CM/48/21/RES

Land to the West of Church Lane South of Horsemere Green Lane Climping

Approval of reserved matters following the grant of CM/1/17/OUT for the erection of 300 No dwellings & a building within use class E, together with public open space, LAPs, LEAP & ancillary works, including car parking & drainage arrangements, with access off Church Lane & Horsemere Green Lane. This application may affect the setting of listed buildings & is in CIL Zone 4 (HSP2) & is not CIL Liable

I have reviewed the amended plans and relevant statements and my concerns remain, these include the following:

English bond in buff/brown brick
Colour to match The Laurels, Horsemere Green Lane

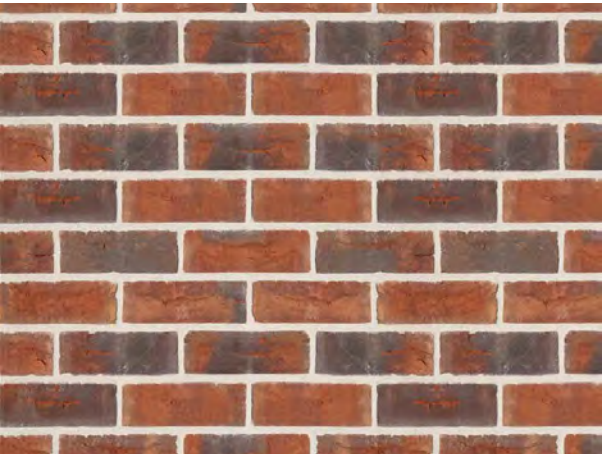
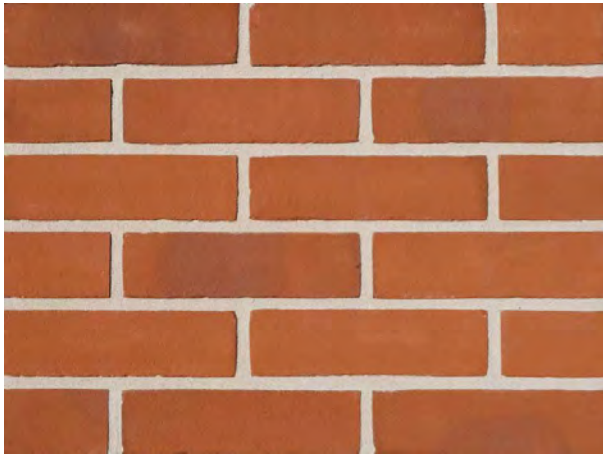
- The choice of a buff coloured brick is questions as it is not reflective of the locality – reference is made to the Laurels, however, on viewing this house it is clear that the brick are not buff coloured i.e. a yellow colour!
- The layout of the development is still close to the historic core of the parish and in contrast with the illustrative masterplan provided as part of the outline application.
- The design of the houses, especially some of them, remains problematical and their comparison to the older ones within the parish is questioned.
